**From:** Martyn White  
**Sent:** 31 August 2018 11:22  
**To:** Planning.Responses  
**Subject:** AB/69/18/PL

AB/69/18/PL

Replacement of French doors with folding sliding doors on rear elevation & replacement of 3 No. air conditioning units

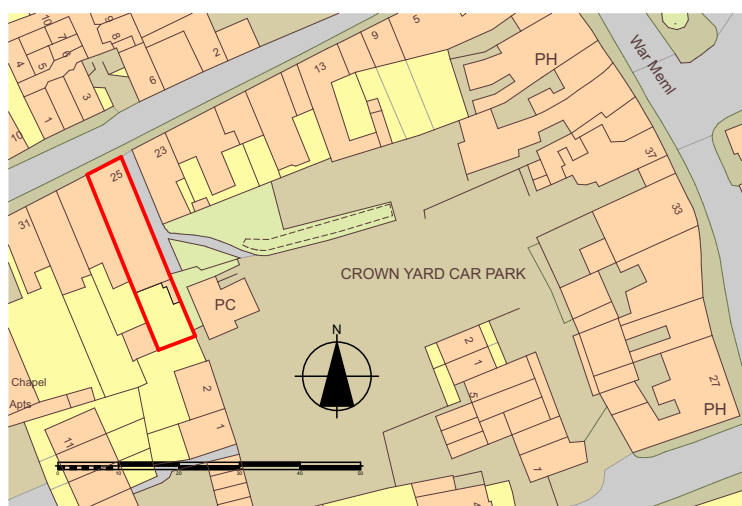
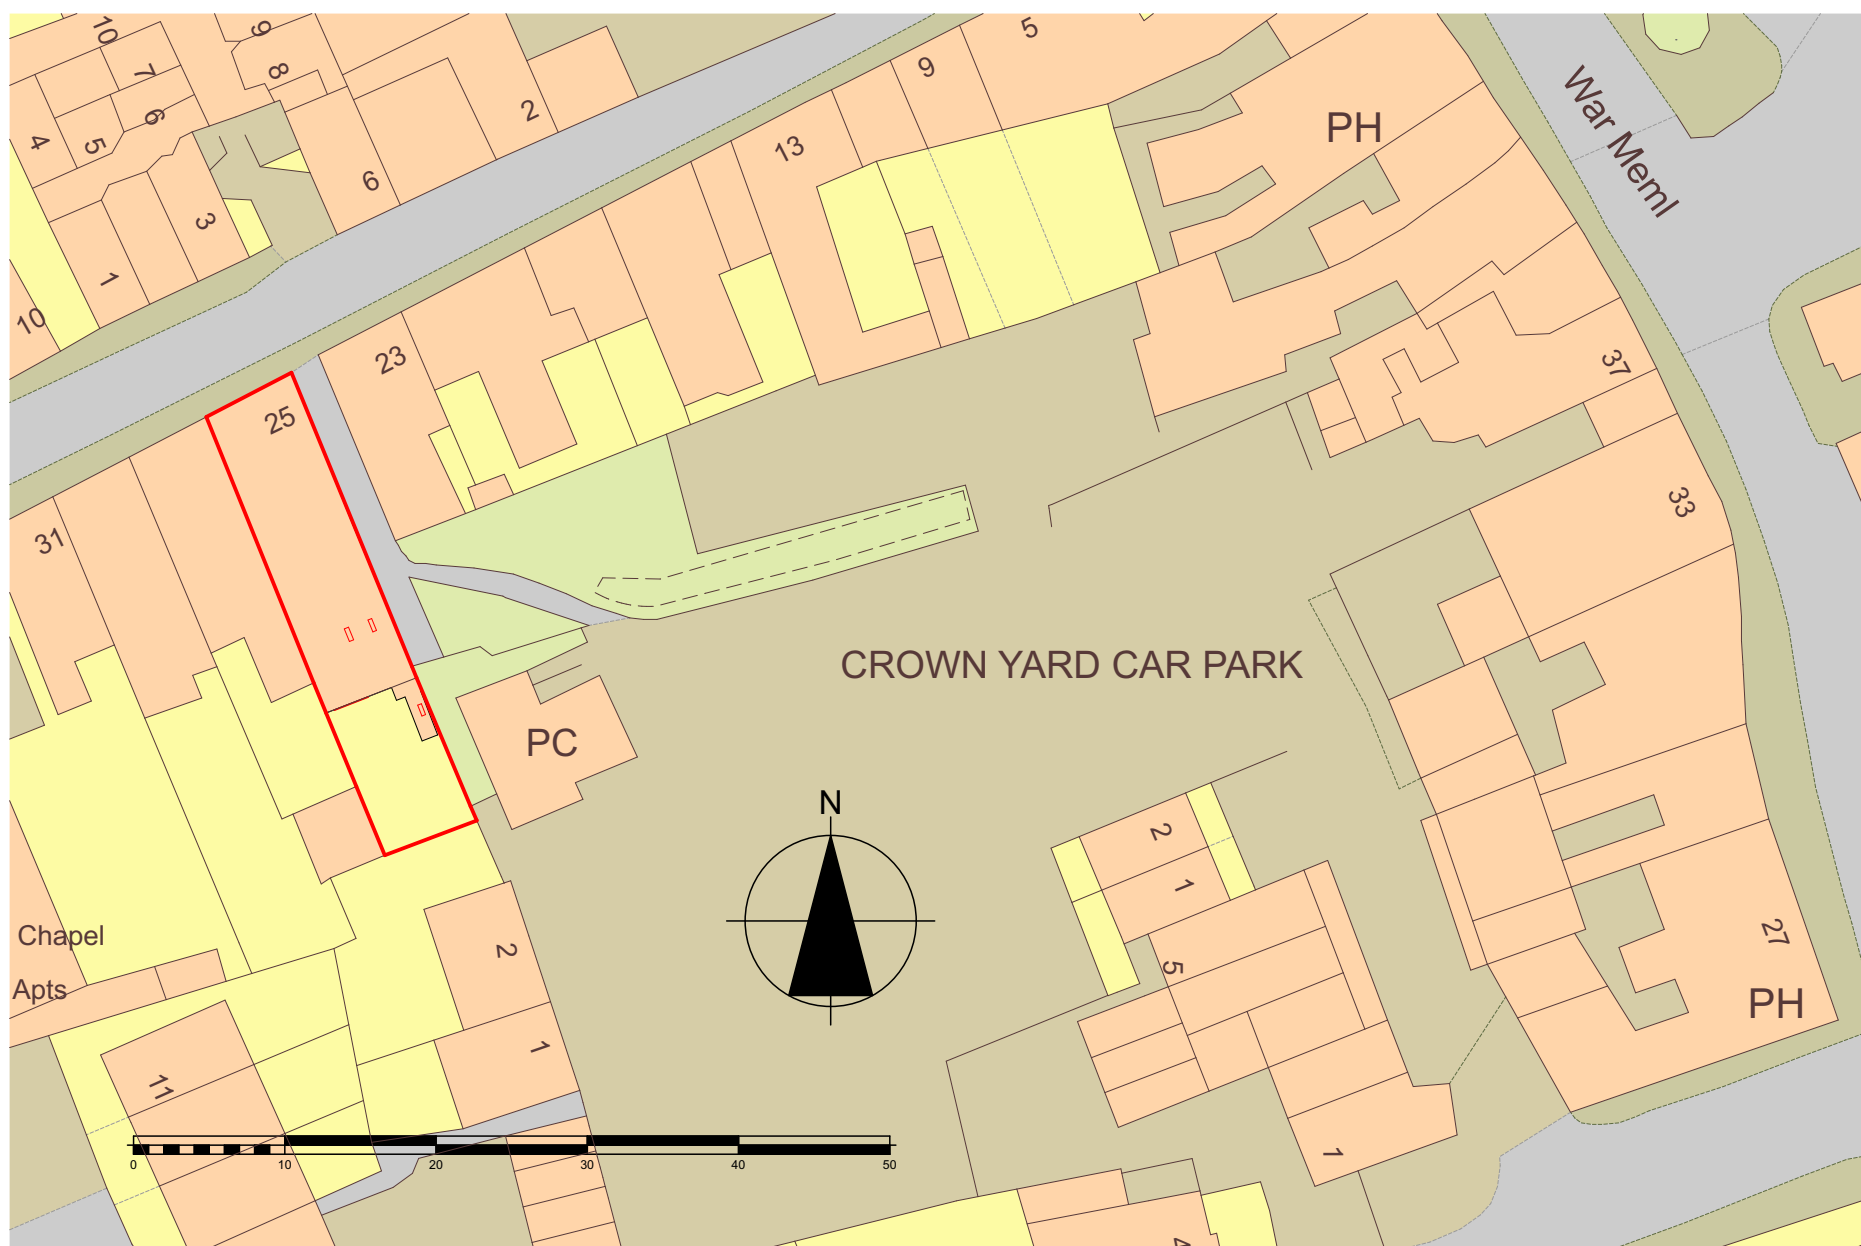
The property concerned is a locally listed building or structure of character. It is located within the heart of the conservation area, where there is a presumption in the preservation and enhancement of the established character. It is noted that the window is located to the rear of the building, where limited views may be visible from the neighbouring car park. As such the impact of such a window is limited. It is therefore considered that this element of the proposal will have a neutral impact upon the conservation area.
